M25 junction 10/A3 Wisley interchange TR010030 9.5 DCO Application Errata Schedule

9.5 DCO APPLICATION ERRATA SCHEDULE

Regulation Number:	Regulation 5(2)(q)
Planning Inspectorate Scheme Reference	TR010030
Application Document Reference	TR010030/EXAM/9.5
Author:	M25 junction 10/A3 Wisley interchange project team, Highways England and Atkins

Drawing Title: <b>SCHEME LAYOUT PLANS REGULATION 5(2)(o)</b>	
SHEET 28 OF 31	
Client: <b>TR010030/APP/2.8</b>	Rev: <b>3</b>
HE PIN: HE551522	Scale: 1:1000 Original Size: A1

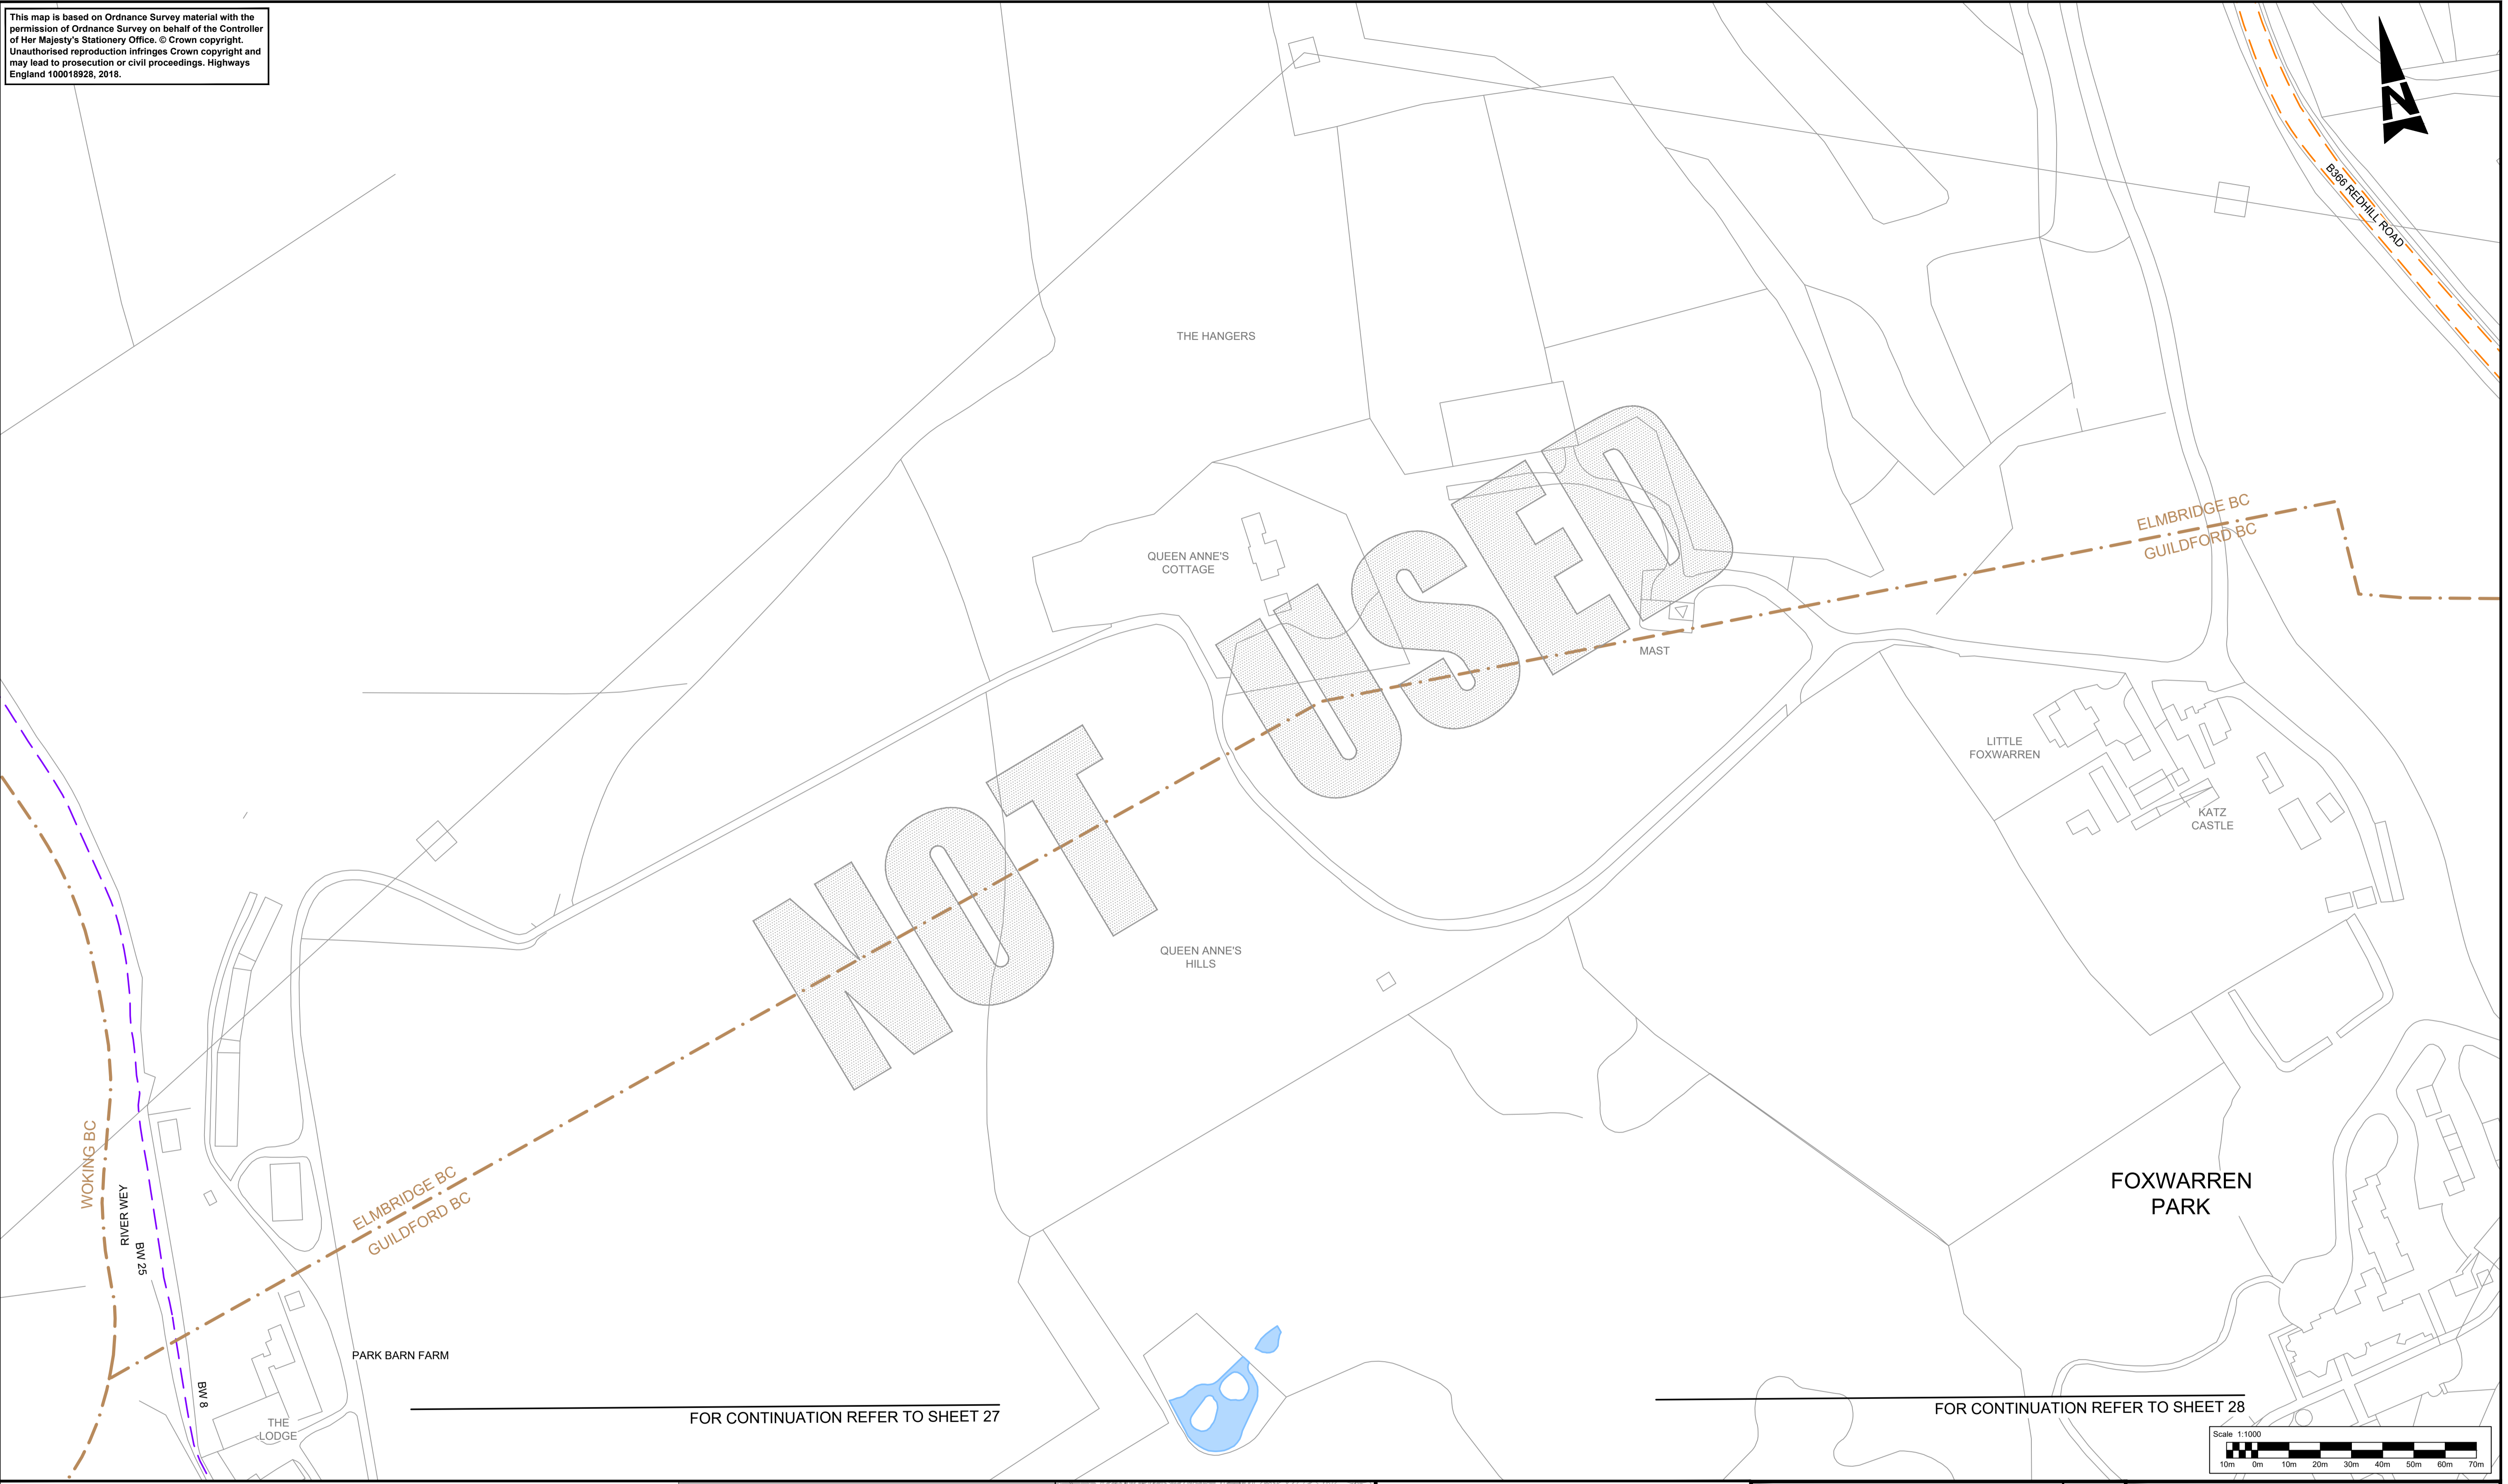
PINS Application Document Reference	Document name:	Section	Nature of Erratum and explanation	Correction
APP-013	2.8 Scheme Layout Plans (Sheets 11-31 of 31)	Sheet 28 of 31	Incorrectly drawn boundary for the tree preservation order to be protected.	Boundary redrawn up to the DCO boundary.
APP-023	4.1 Statement of Reasons Appendix C: Common land sheets 5 and open space report	Appendix C, Table C.1, C.3, C.4, C.5, C.6 and C.7	“Error! Not a valid link” displayed instead of the Table.	Insert Table into the document. Provided on 24 July 2019 as part of response to S51.
APP-023	4.1 Statement of reasons Appendix C	Table C.7	Table C.7 does not accommodate changes to the Special land dimensions	Additional Land Parcels need to be inserted into C.7.
APP-039	5.3 Habitats Regulations Assessment Figures	Whole document	Figures have not appeared online when submitted at DCO Application. We were asked to update at S51. Since then PINS have further asked us to change some of the ordering of the plans and Contents Lists.	Document Rev 2.0 provided to PINS on 5 November 2019.
